August 21, 2013

**Subject: Canal Landing New Yard – Phase 1  
40 West Commercial Street  
Applicant: New Yard, LLC  
Amended Site Plan Review Comments**

We have received and reviewed your review comments dated August 19, 2013 for the Canal Landing New Yard project and offer our responses to these comments. For ease of reference we have repeated each comment in *italics* with our response following.

SHEET: C-2.1

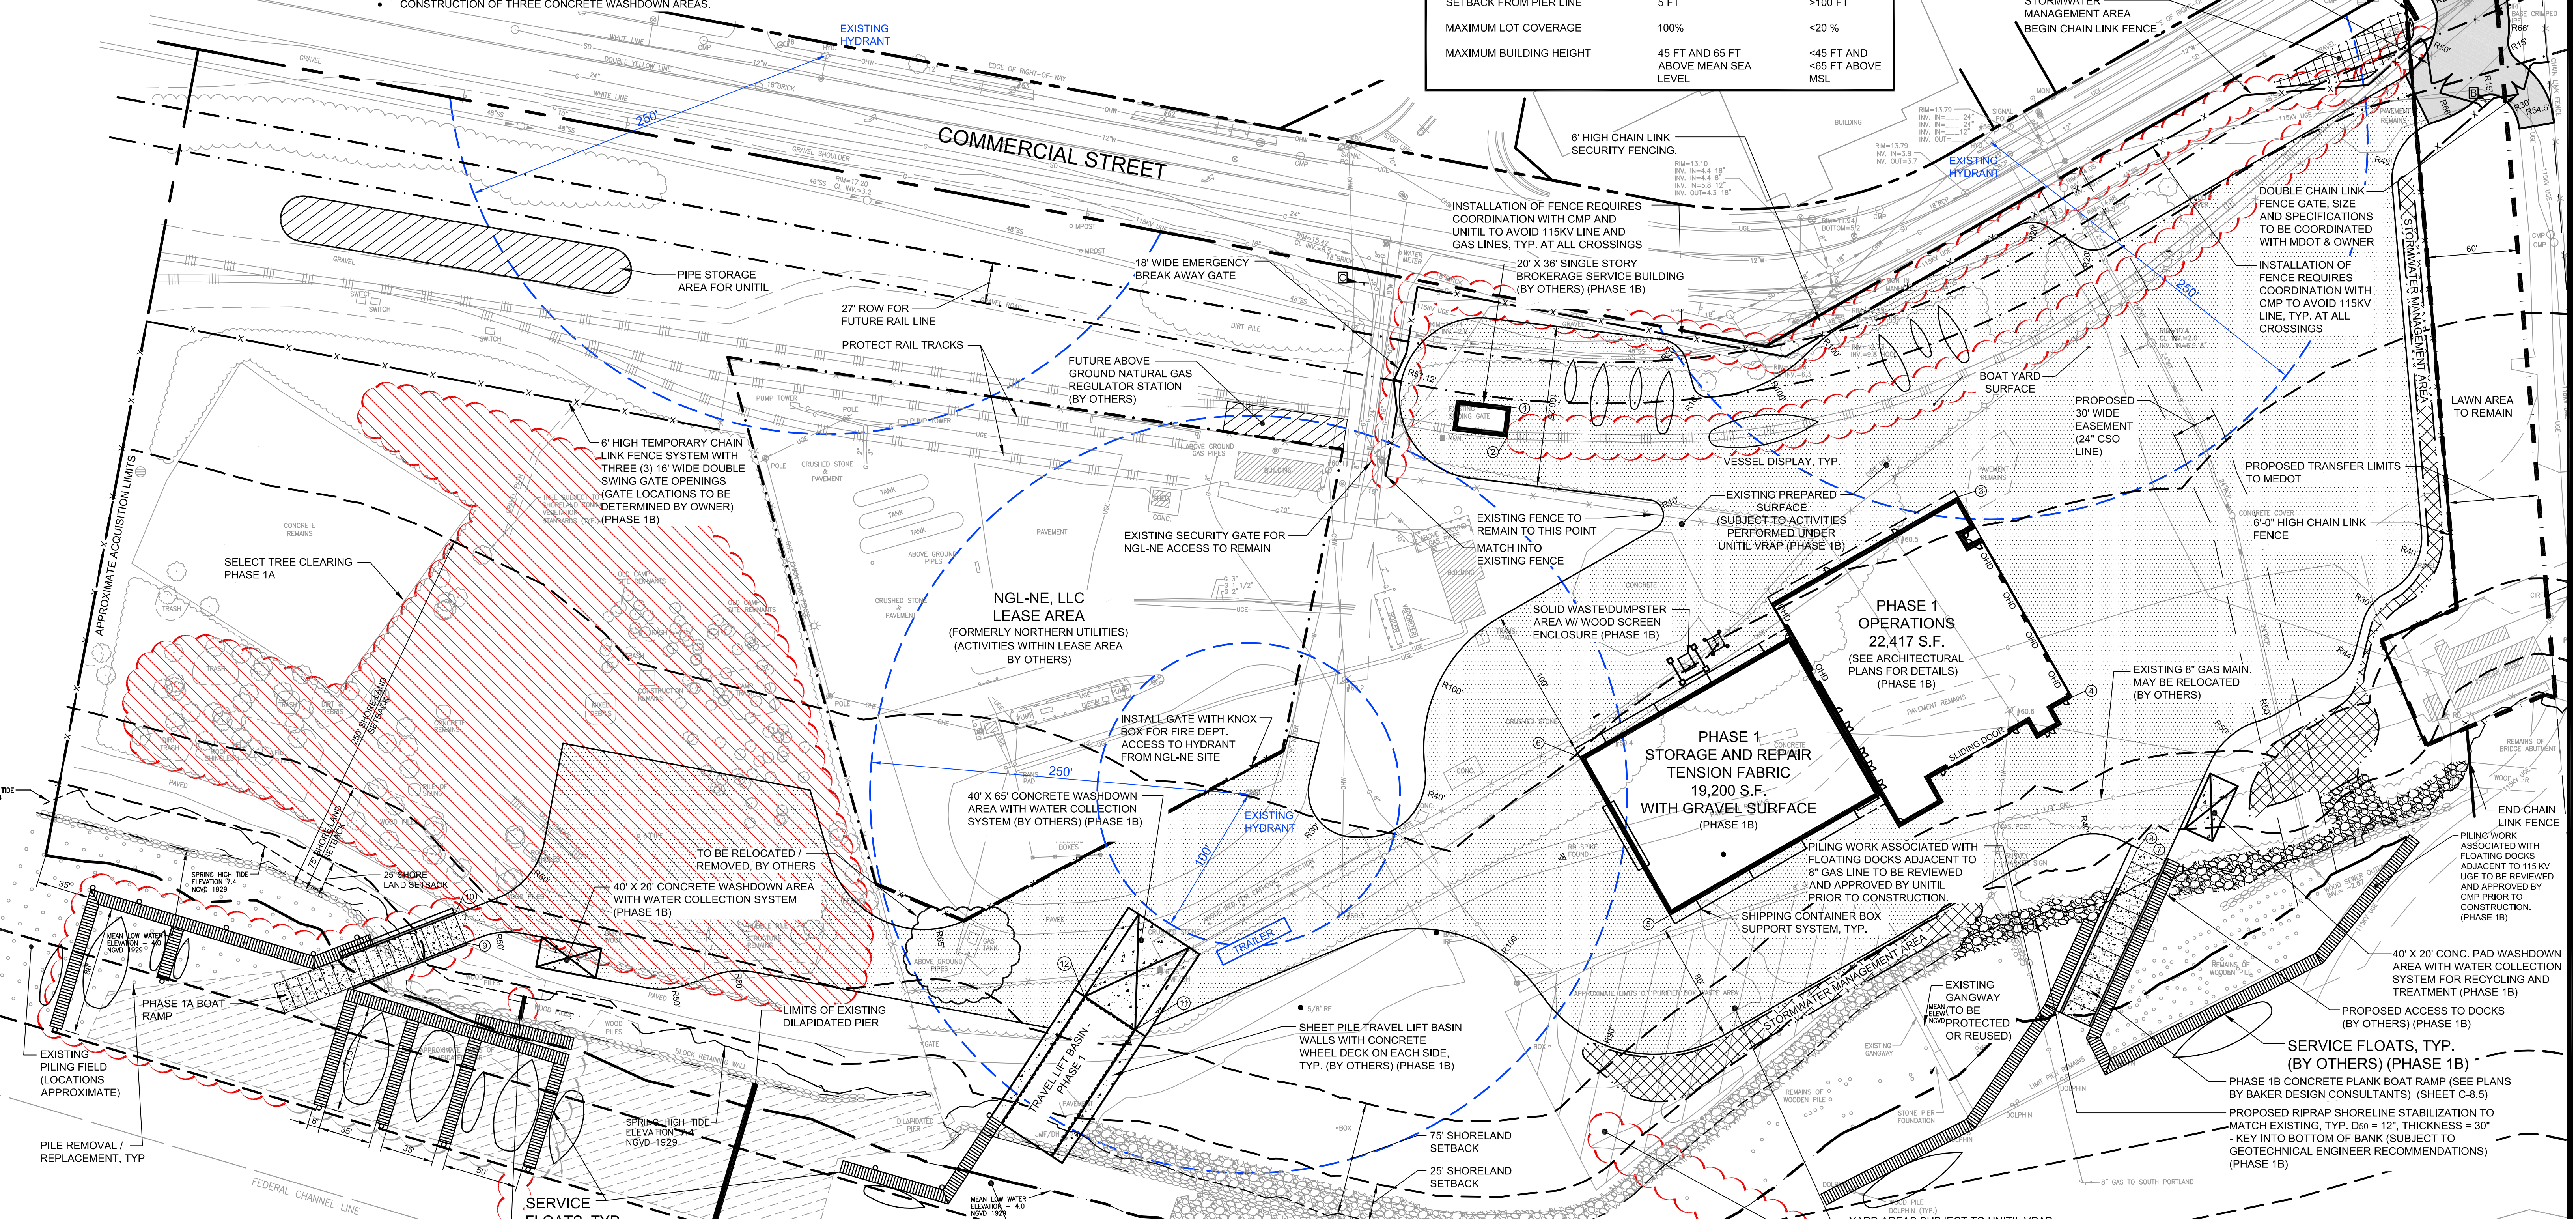
*The proposed construction trailer is not shown on the phasing plan. If the trailer is proposed for use beyond the construction of phase 1a improvements: show the location and extent of utility connections; locate the nearest existing fire hydrant; and, describe/show circulation and emergency access to the structure.*

The construction trailer is proposed as only a temporary measure during the Phase 1A period and during the Phase 1B construction. The trailer is not expected to be onsite permanently. The

Phasing Plan has been annotated per the attached figure to depict the trailer location, nearest fire hydrant and circulation/emergency access route.
